Our ref: PL00490033

Your ref: EN010092

**PLANNING ACT 2008 : THURROCK POWER, PROPOSED THURROCK FLEXIBLE
GENERATION PLANT**

Historic England Deadline 5A Response

Figure 3.1: Alternative AIL Access – Western Section

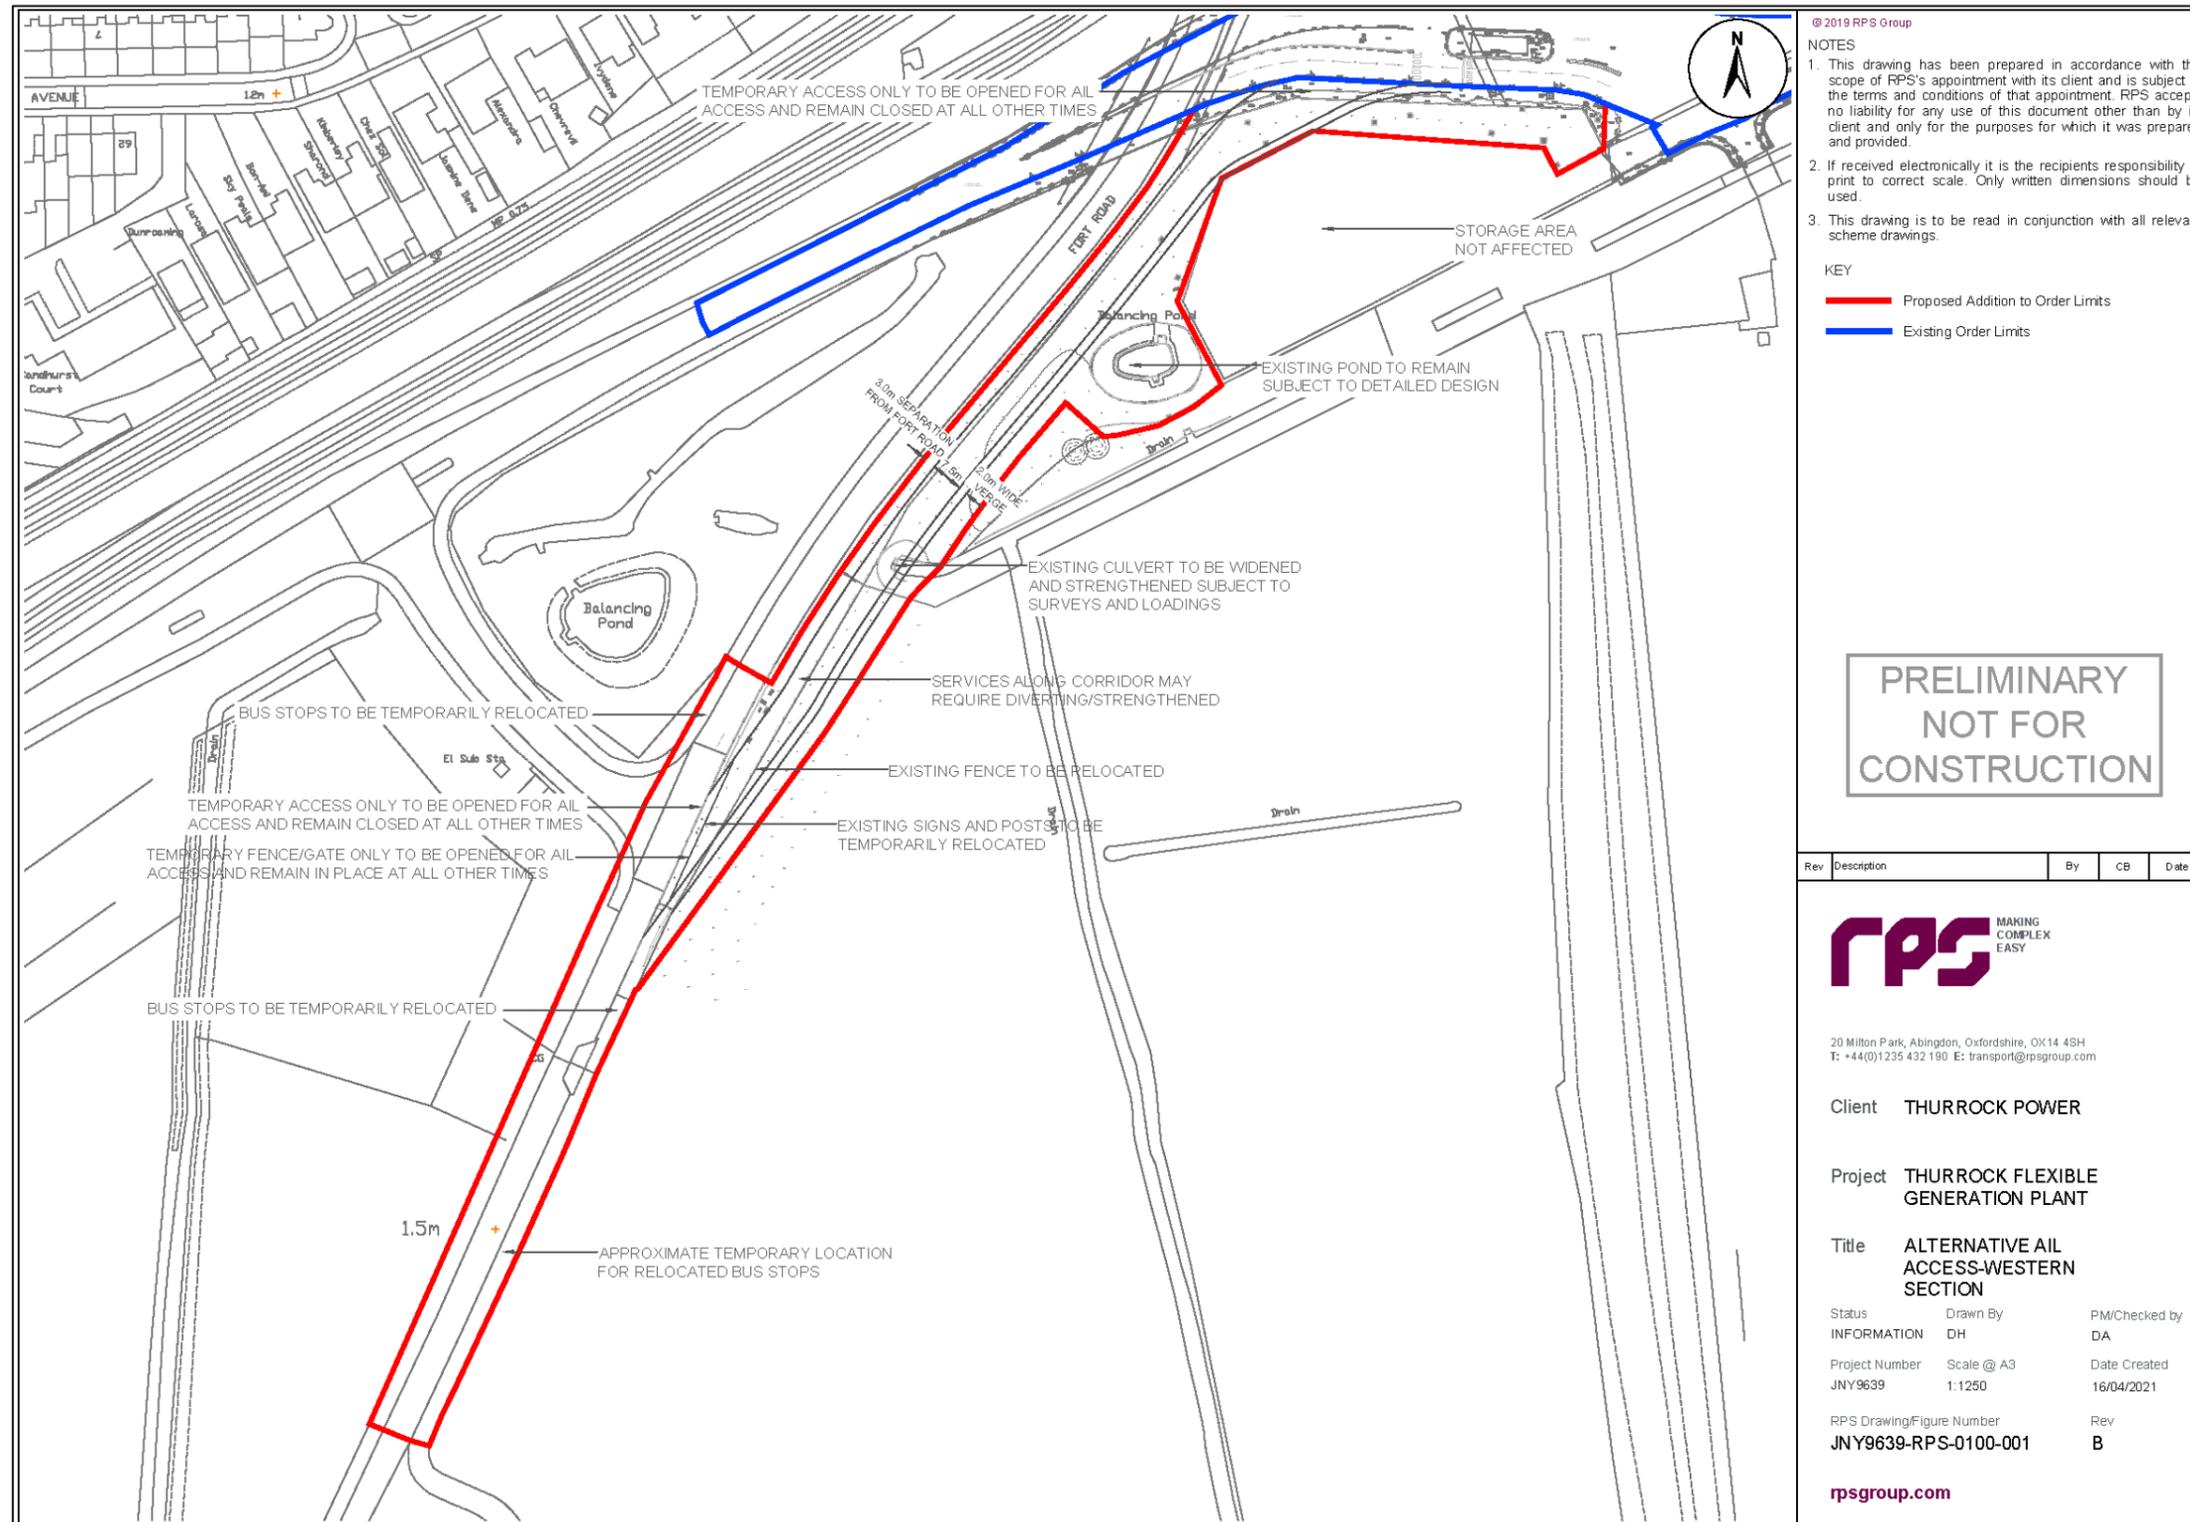
We note that the application includes the proposed removal of part of the historic common known as Tilbury Fort Common and the construction of a new section of access road, with a new junction to Fort Road, c.250m of new 7.5m wide carriageway on the west side of, and parallel to, Fort Road (Western Section). This is required for a small number of vehicle movements carrying abnormal loads relating to construction of the powerstation.

Historic England has concerns about the assessment of significance and also the assessment of effect. We believe insufficient information has been provided in the ES Addendum for the effect of the proposed development to be assessed and for the balance to be weighed proportionally by the Examining Authority.

In our opinion, the Examining Authority should consider whether the applicant has taken all possible steps to establish the significance of the area affected by the AILs access (Western Section), and to minimise the harm the development would cause to the significance of the historic environment.
